From: Amanda Scholes on behalf of Planning.Responses
Sent: 30 November 2021 09:31
To: Planning Scanning
Subject: FW: Planning Consultation on: WA/98/21/PL

Engineers Comments Regarding Surface Water Drainage

Application No: WA/98/21/PL
Registered: 19th October 2021
Site Address: Brookview Nursery Eastergate Lane Walberton BN18 0BA
Grid Reference: 496009 106070
Description of Works: Removal of outdoor storage, including caravan and polytunnels and the erection of 7 No. units comprising of 12 offices and 3 workshops, associated parking, drainage and turning spaces (resubmission following WA/58/21/PL). This site is in CIL Zone 3 (Zero Rated) as other development.

Drawing No.	Rev.
D1963-PL100	A

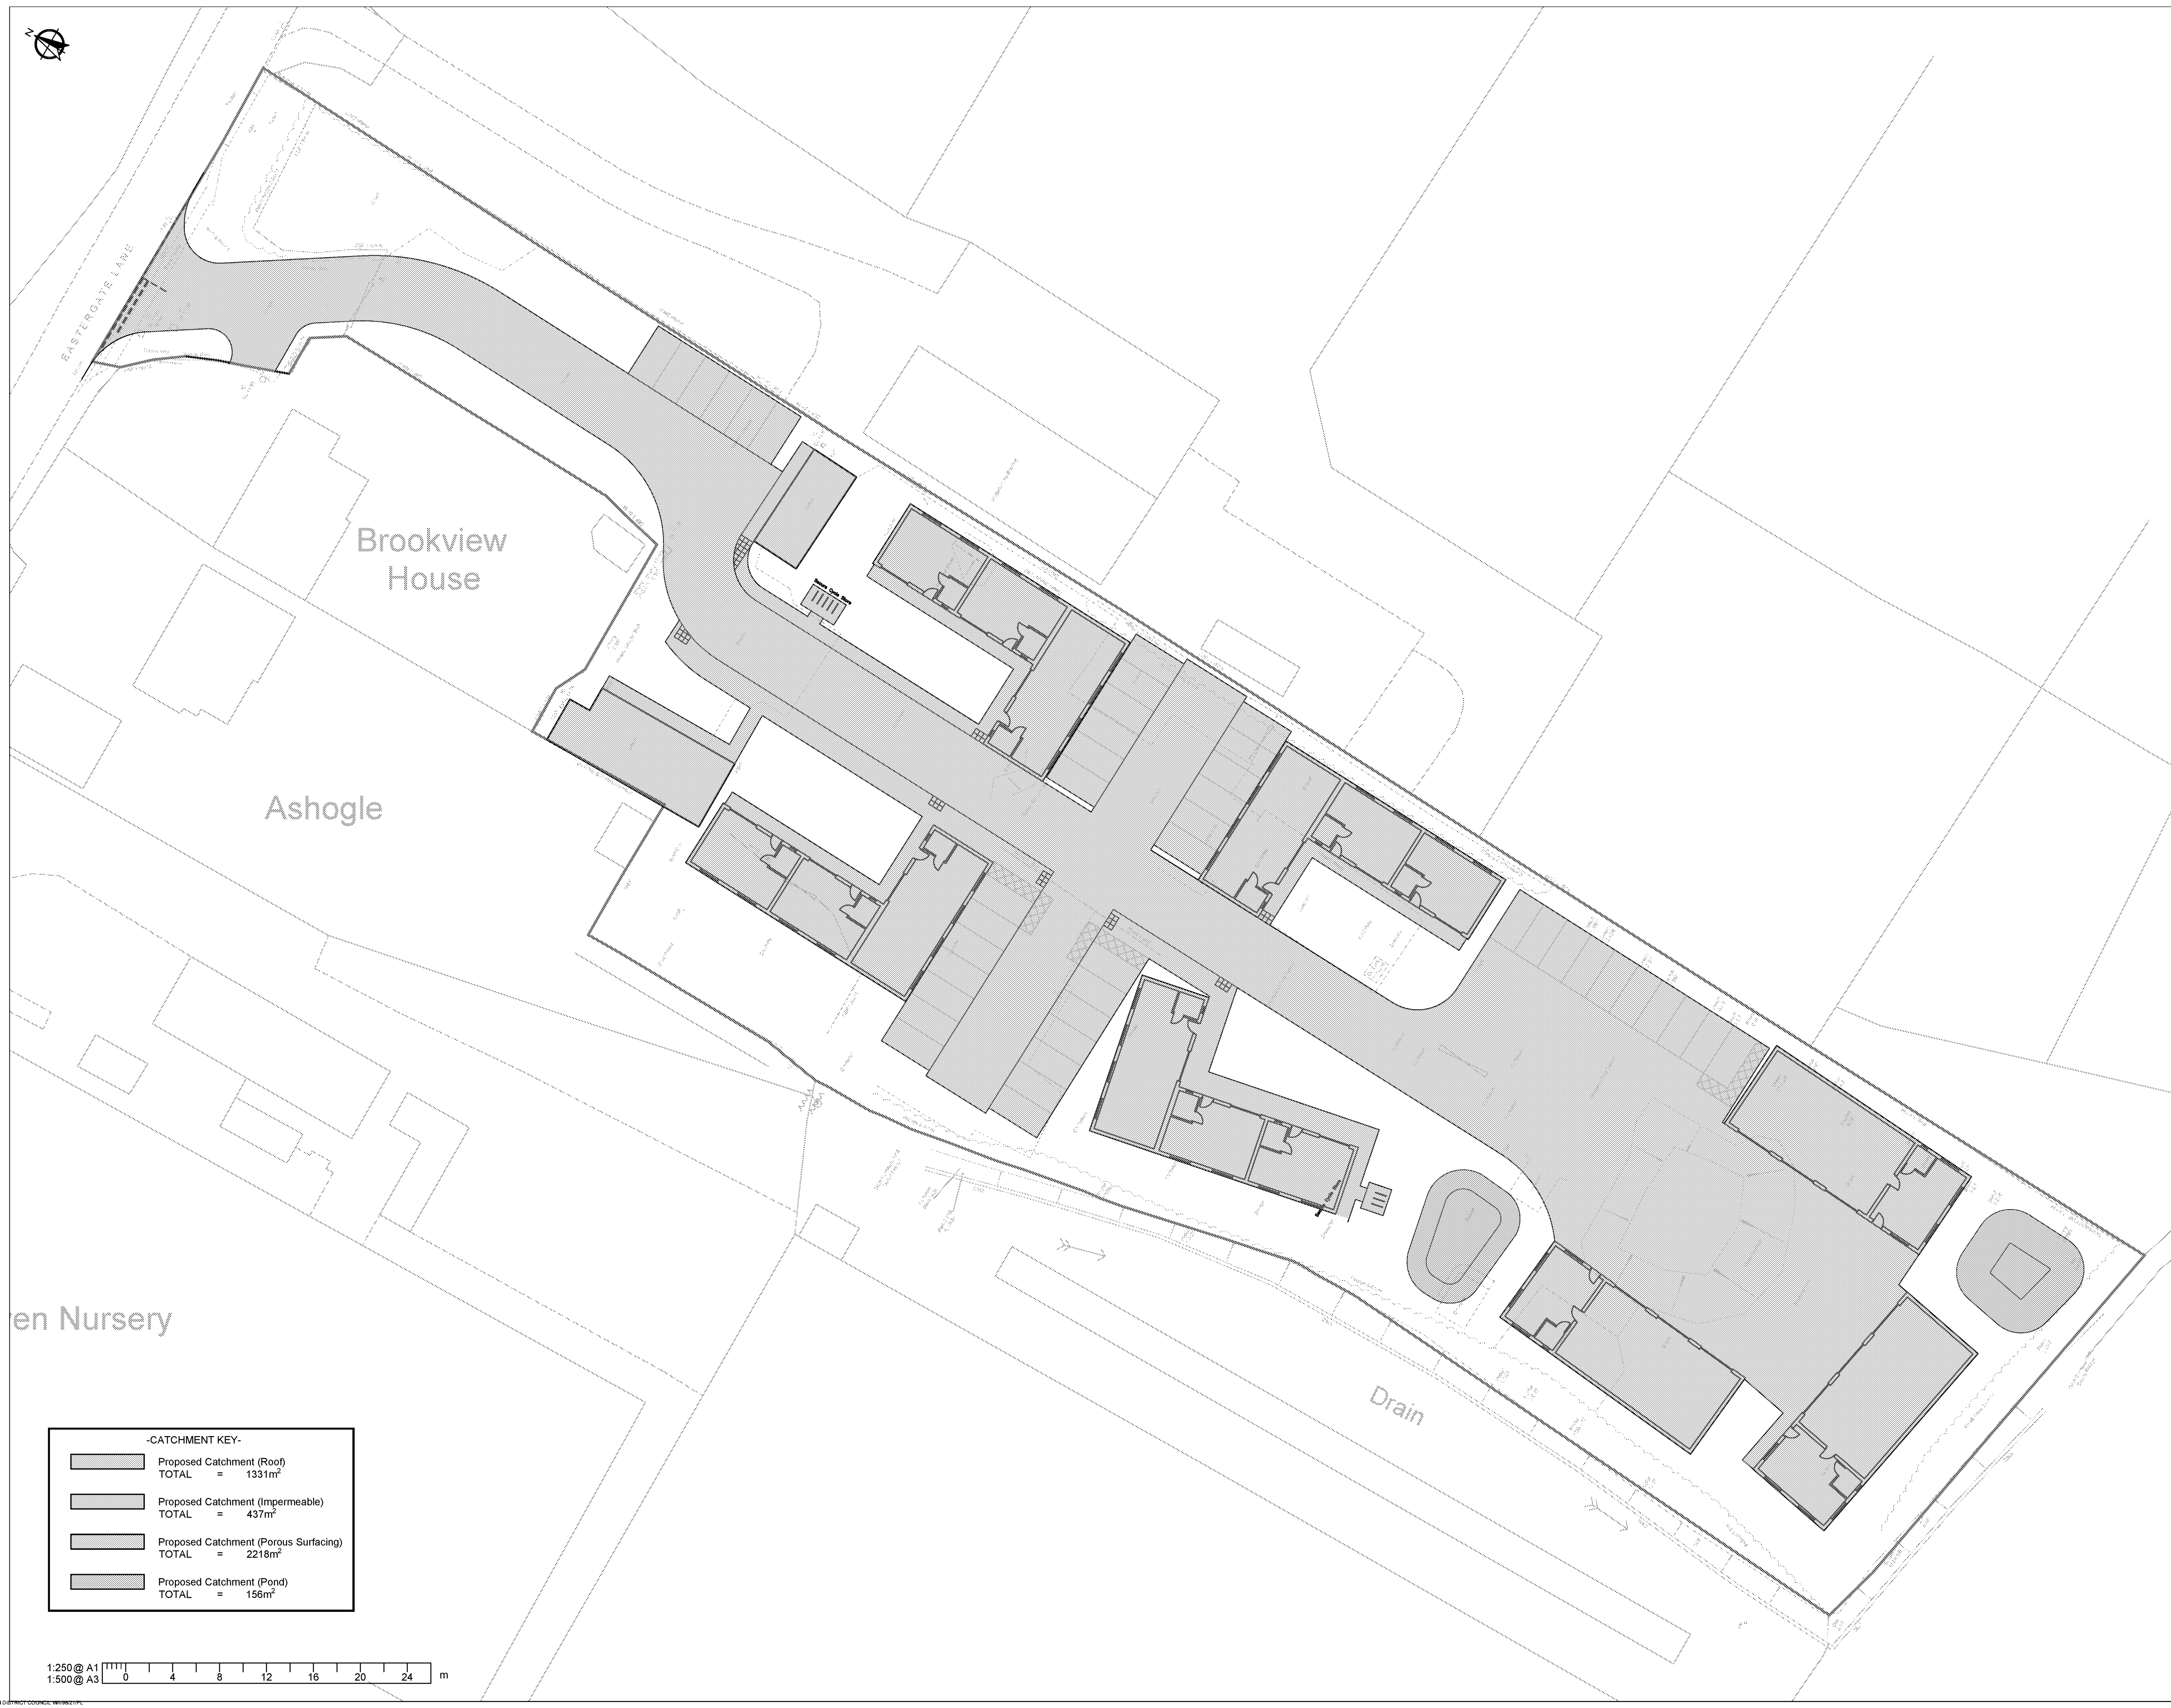
On the basis of an assumption that infiltration will not be viable on the site (due to the expected clay soils and knowledge of the existing surface water drainage system) the applicant is proposing to collect surface water from the roads (via permeable paving) and roofs in two ponds (at the west and south of the site) before discharging it at a restricted rate to the watercourse which runs along the east and west boundaries. **IF** infiltration is found to not be viable following appropriate site investigations then we would support this strategy.

The applicant's Engineers are encouraged to contact us and agree the level of winter groundwater monitoring and infiltration testing that is required for the site. If the proposed strategy is taken to detailed design stage then we would expect to see the discharge rates restricted to the greenfield 1 in 1 year runoff rate during all events up to and including the 1 in 100 year rainfall event with climate change. An alternative approach would be for discharge rates to be limited to a range of greenfield rates, based on the 1 in 1, 1 in 30 and 1 in 100 year storm events. **The current combined proposed discharge rates of 2l/s and 5l/s are likely to exceed this requirement.**

All buildings, structures and fences are to be kept a minimum of 3m from the watercourse to ensure access for maintenance.

"Development shall not commence, other than works of site survey and investigation, until full details of the proposed surface water drainage scheme have been submitted to and approved in writing by the Local Planning Authority. The design should follow the hierarchy of preference for different types of surface water drainage disposal systems as set out in Approved Document H of the Building Regulations, and the recommendations of the SuDS Manual produced by CIRIA. Winter groundwater monitoring to establish highest annual ground water levels and winter Percolation testing to BRE 365, or similar approved, will be required to support the design of any Infiltration drainage. No building / No part of the extended building shall be occupied until the complete surface water drainage system serving the property has been implemented in accordance with the agreed details and the details so agreed shall be maintained in good working order in perpetuity."
